WEST SUSSEX COUNTY COUNCIL CONSULTATION

TO:	Arun District Council FAO:Ms M Tomalova
FROM:	WSCC - Highways Authority
DATE:	19 November 2020
LOCATION:	Aronel Cottage Nursing Home 5-11 Highfield Road Bognor Regis PO22 8BQ
SUBJECT:	BR/234/20 Three storey side extension comprised of twenty nursing units linked to the existing nursing home building. This site is in CIL Zone 4 (Zero Rated) as other development.
DATE OF SITE VISIT:	
RECOMMENDATION:	More Information
S106 CONTRIBUTION TOTAL:

Drawing Title:
PROPOSED SITE PLAN

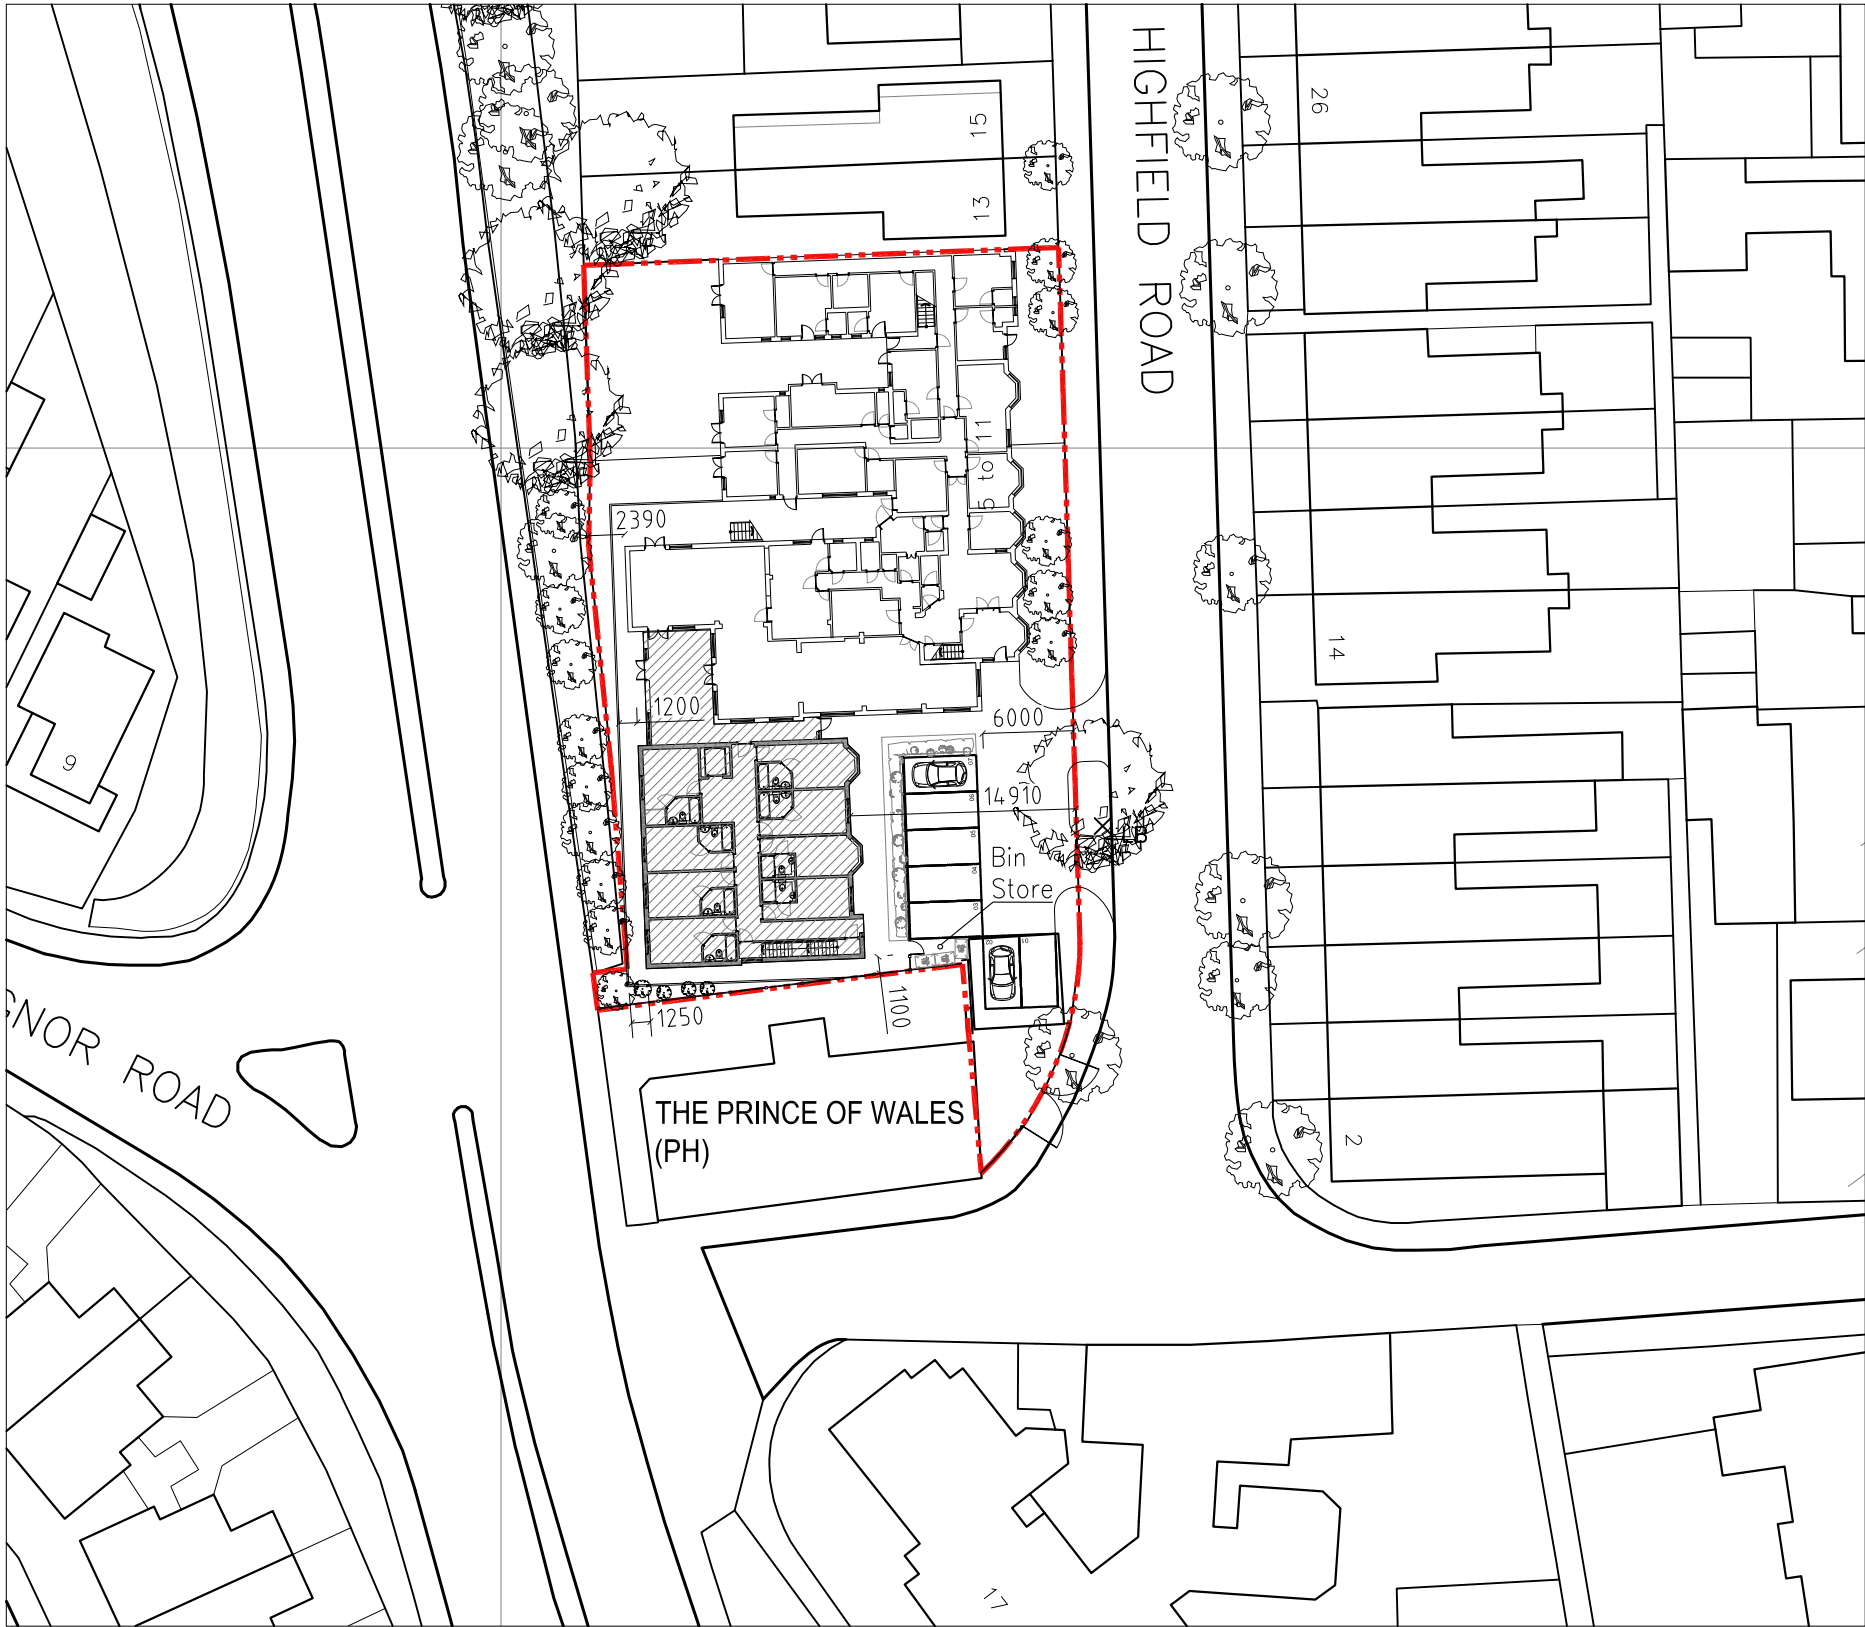
The site has two existing access/exit points onto Highfield Road and operates an in/out set up. The application form states there are currently two parking spaces however, the hardstanding has the capacity for more, as was observed when visiting the site. The application form states that 5 more parking spaces are proposed (total of 7 marked out spaces). Two of which appear to be in front of the garage/store which would make accessing the two end spaces behind The Price of Wales Public House impossible and render them unusable or involve double/tandem parking. Or is it the case that the garage/store is being removed to provide these two parking spaces? All parking spaces should measure 2.4m wide by 4.8m long and must have 6m behind each space to allow for manoeuvring in and out of the spaces, in-line with guidance in Manual for Streets (MfS) on parking layouts.

There is no justification provided for the level of parking proposed, nor any detail relating to the number of staff (existing & proposed). Under WSCC's Guidance at Parking in New Developments there is no set parking standard for Care/Nursing homes (class C2). Site-specific assessment based on a travel plan and specific operational needs is how parking and cycle spaces should be assessed. After reviewing the submitted documents there is no detail relating to staffing numbers, visitor numbers or any type of surveys specific to this site's use. The Design & Access Statement states that Highfield Road falls within a control parking zone, this is incorrect. This section of Highfield Road is not subject to any parking restrictions or resident parking permits.

- Are there any surveys to indicate how people travel to the site?
- Information is required on the level of staff & shift patterns.
- Clarification is sought on if the garage/store is to be demolished?
- Have any parking surveys been carried out on Highfield Road to see what capacity if any there is to accommodate any on street parking that may overspill from the development?

The site would benefit from a Travel Plan to inform what parking is required on site and to encourage the use of sustainable travel modes. Please re-consult once the above information has been provided.
